# **KIRKLEES METROPOLITAN COUNCIL INVESTMENT & REGENERATION SERVICE**

### **DELEGATED DECISION FOR DISCHARGE OF CONDITION A1 - NOTIFICATION OF A PROPOSED DEVELOPMENT UNDER LOCAL OR PRIVATE ACTS OR ORDER**

**Reference no.** 2026/CL/90304/W

| <b>Description</b> | Prior approval for alterations to<br>bridge Bridge MVL3/77, Bankhouse<br>Road, north of Milnsbridge (within a<br>Conservation Area) |

Drawing Title
Prior Approval - MVL3/77 Bankhouse Road - Existing and Proposed Elevation and Section

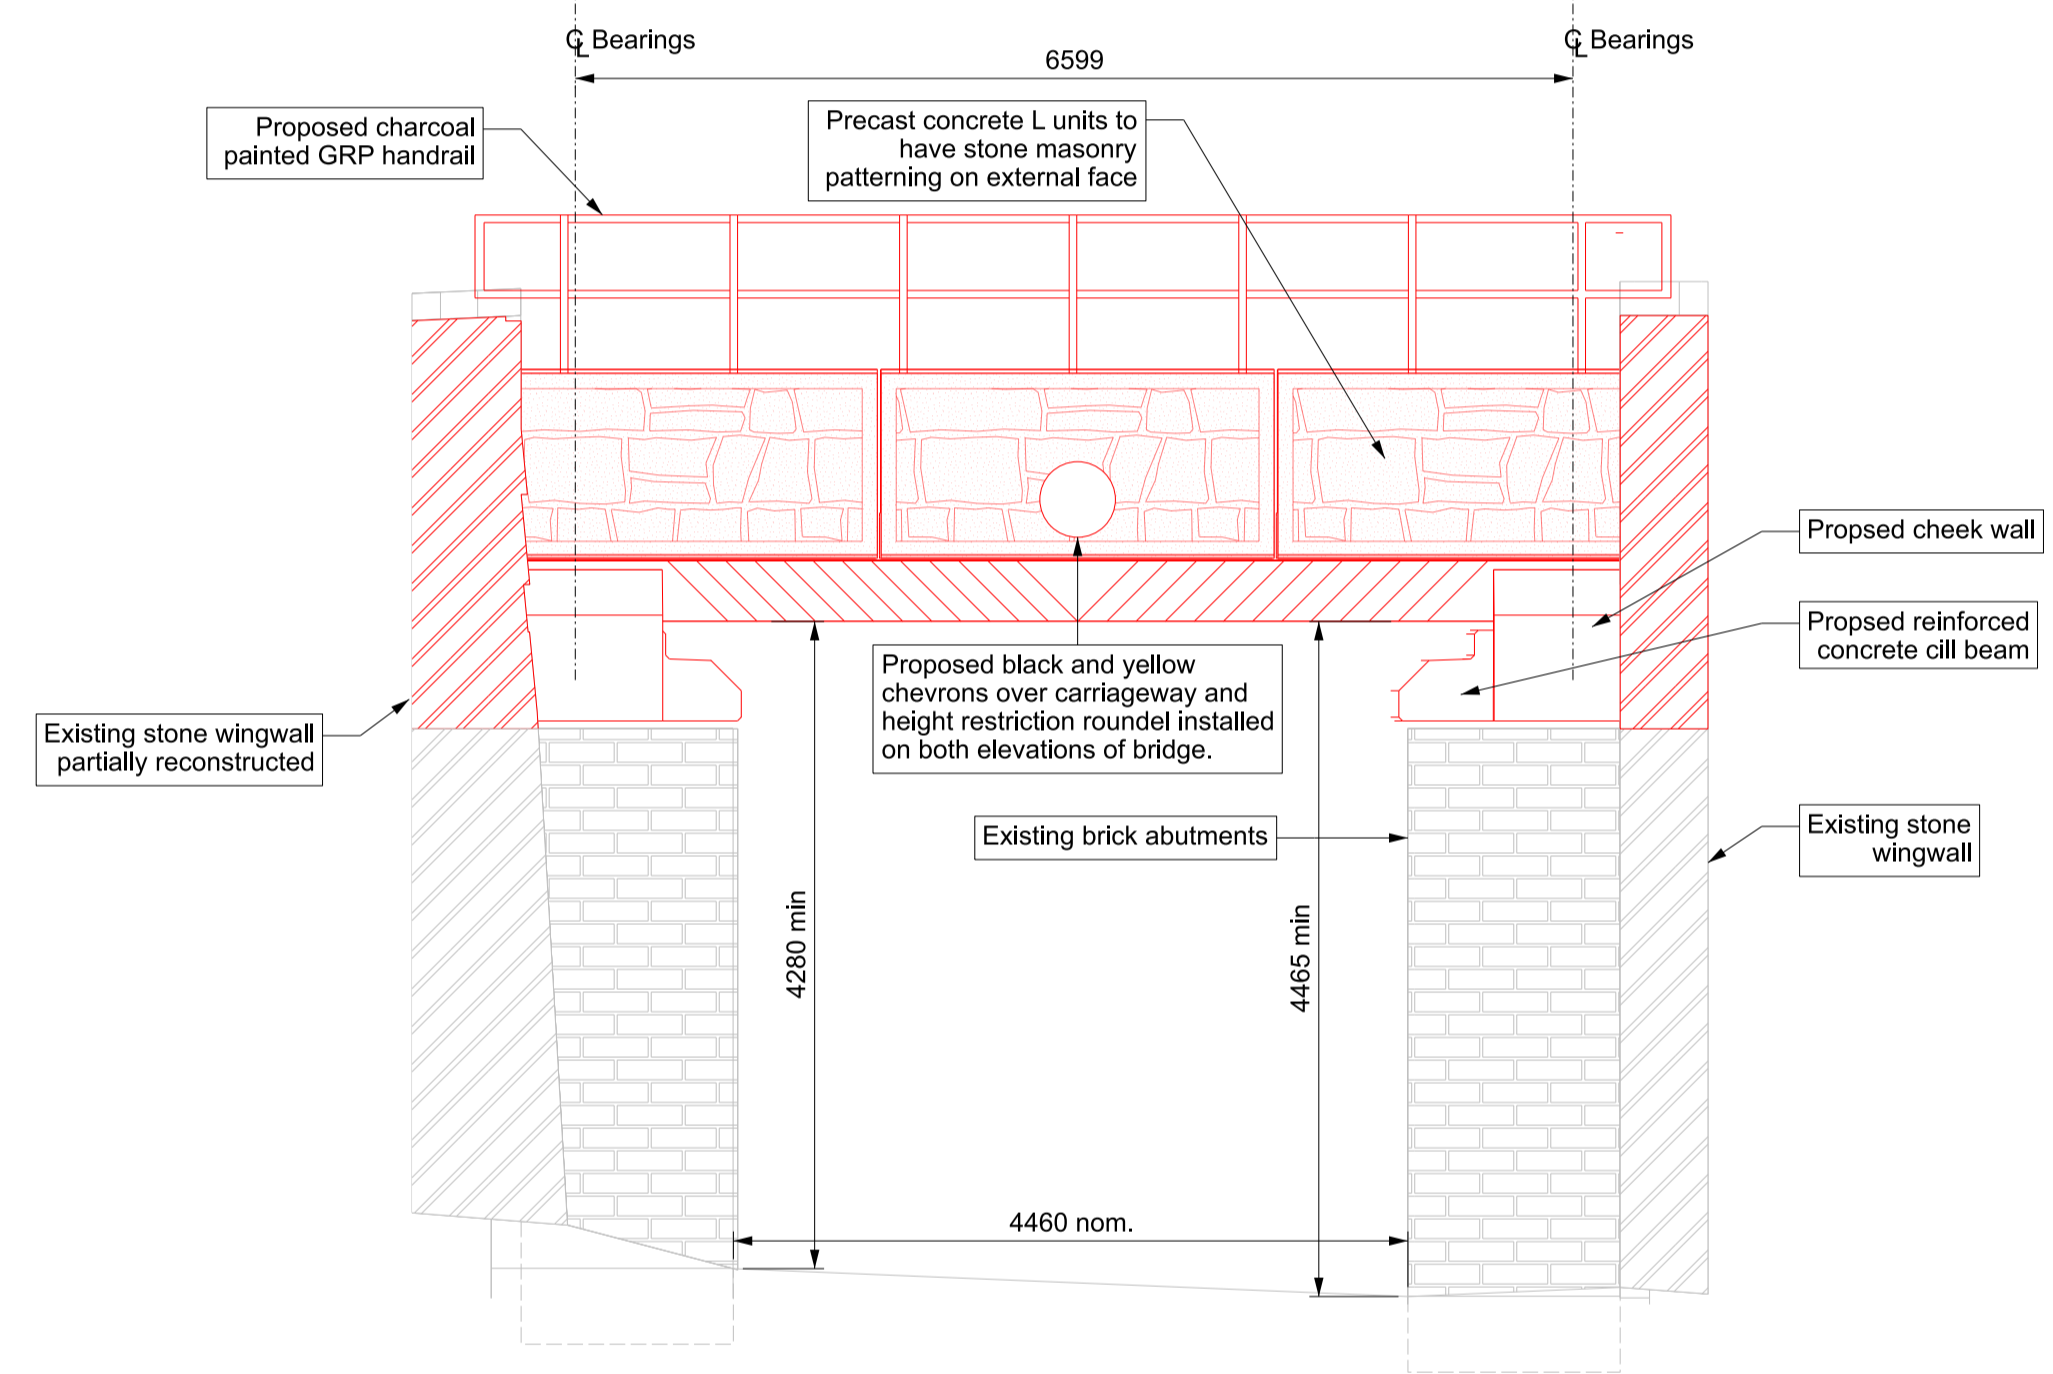
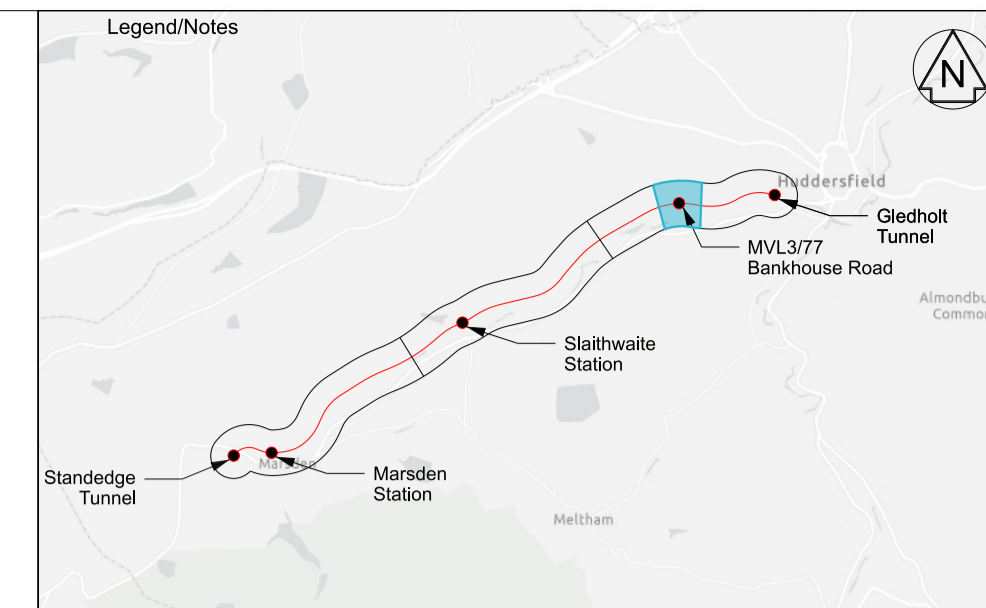
- *The pre-cast concrete L-units shall be a finished with natural stone cladding design pattern to match the natural coursed stones below. The concrete shall match the existing natural stones by colour, texture and coursing.*
- *The GRP handrail shall be finished in a black or green colour*

The proposed works to the bridge would maintain or re/use original features such as the stone wingwalls. The existing wrought iron parapet to the north will be replaced by pre-cast concrete L units which is on the boundary of the Conservation Area. The proposed works would have a small impact on the character and appearance of the Milnsbridge conservation area through the replacement of the ironwork deck and parapet structure, and a negligible impact to the visual amenity of the surrounding area.

- The submission of material finish/detail to be agreed by the LPA
- The GRP handrail shall be finished in a black or green colour.

1. Notwithstanding the submitted plans, a sample of the parapet finish[es] shall be submitted to and approved by the Local Planning Authority, prior to their installation. The external treatment of the parapet finish[es] shall reflect the retained stonework of the bridge in terms of colour, texture, finish and coursing.

2. The GRP handrail shall be finished in a black or green powder coating
